Application No: LU/117/20/HH
Site Address: 68 Armada Way Littlehampton BN17 6QY
Description of works: Two storey side and rear extension, and alterations to existing garage to form habitable accommodation.

Thank you for your internet representation made on 23rd June 2020 which has been recorded as an objection with the comments as follows:

DRAWING TITLE
PROPOSED FLOOR PLANS & ELEVATIONS

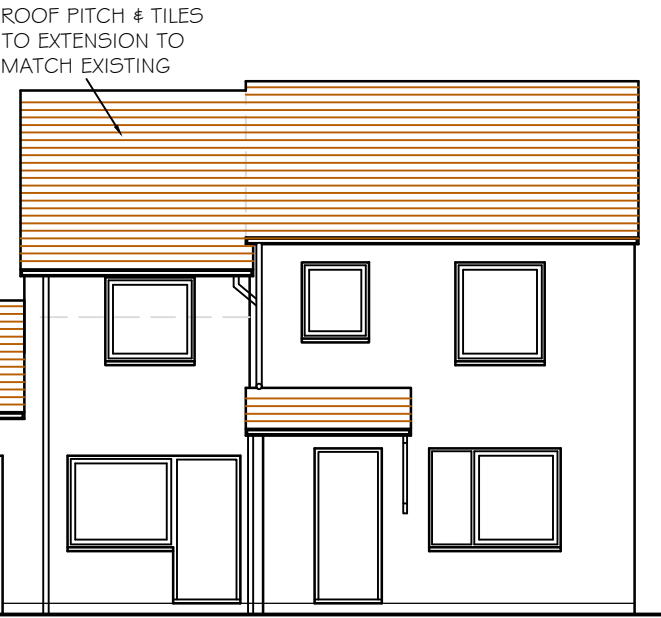
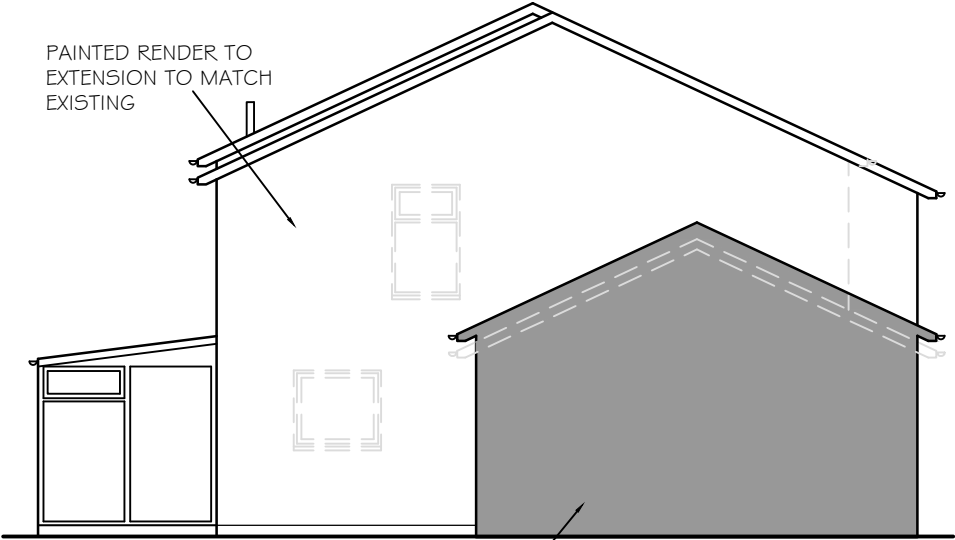
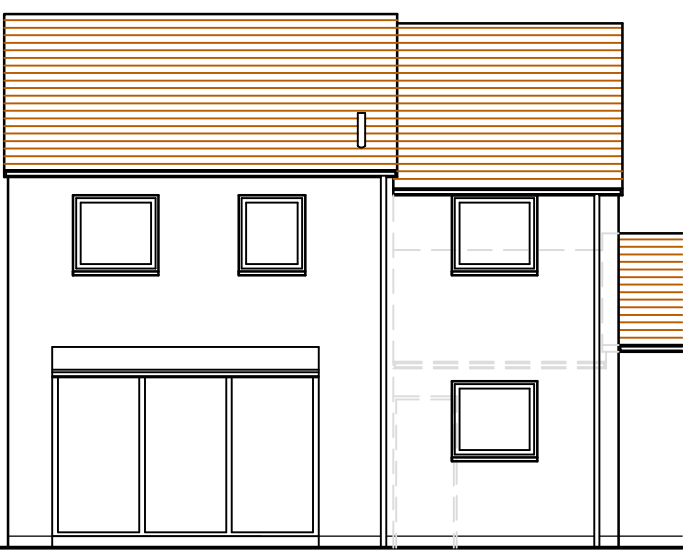
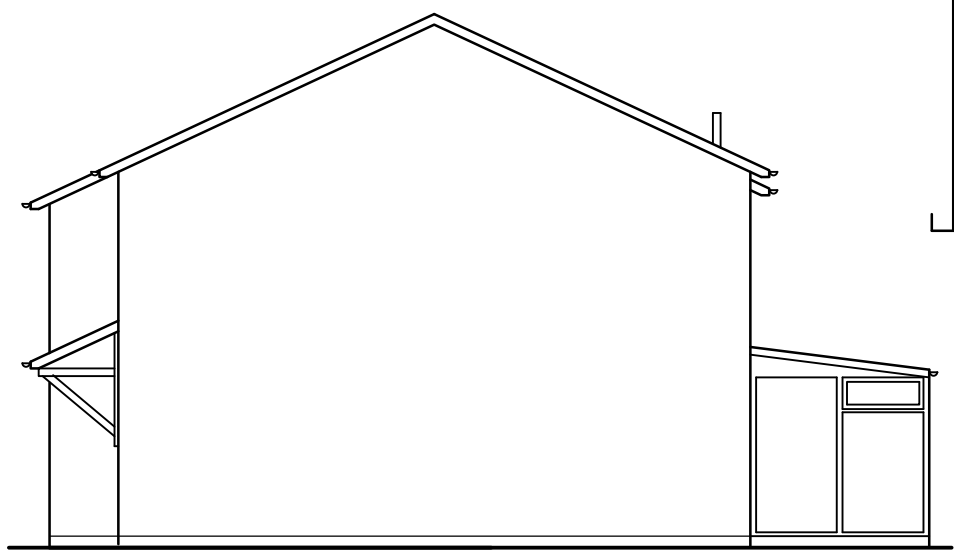
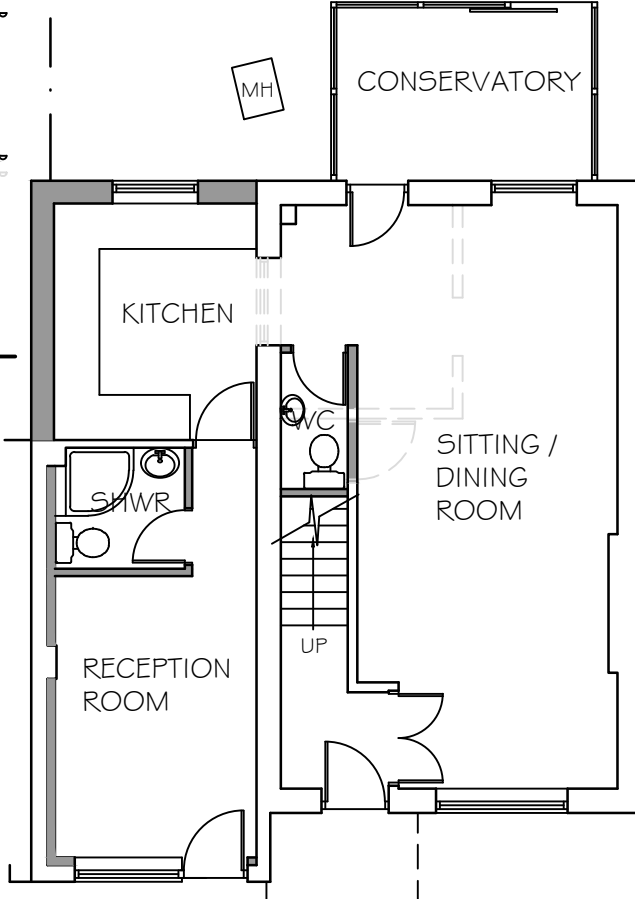
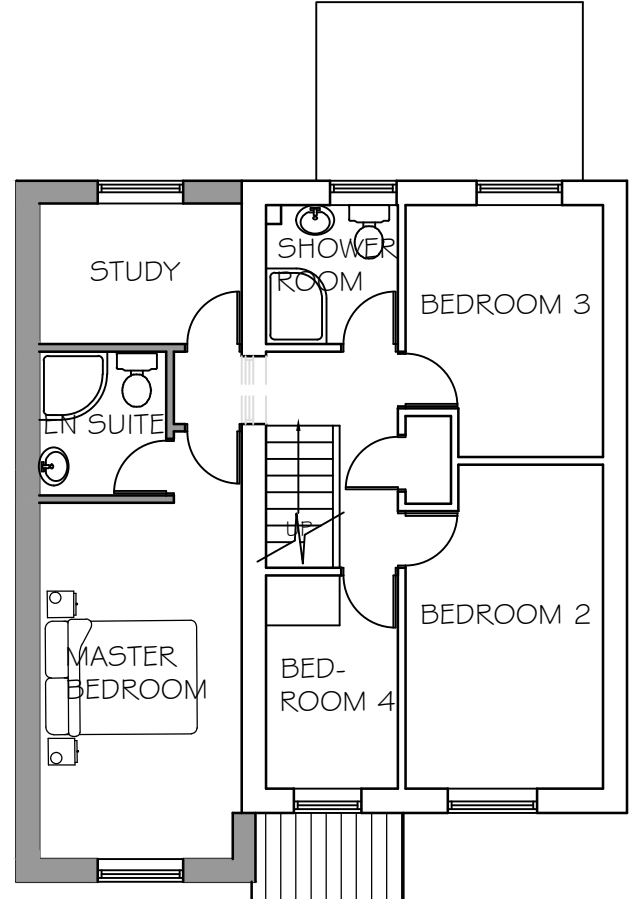
The Town Council's Planning and Transportation Committee considered this matter at its meeting held on Monday 22nd June 2020 and objected to the application. The proposals were out of keeping and overbearing in relation to the area and should be opposed on the grounds that they went against Policy D DM4 of the Local Plan re: Extensions and alterations to existing buildings which states that "when considering applications for extensions and alterations to existing buildings, the Council will require that: a. the extension or alteration sympathetically relates to and is visually integrated with, the existing building in siting, massing, design, form, scale and materials; b. the extension or alteration is visually subservient to the main building and provide a high standard of amenity; c. the extension or alteration does not have an adverse overshadowing, overlooking or overbearing effect on neighbouring properties".
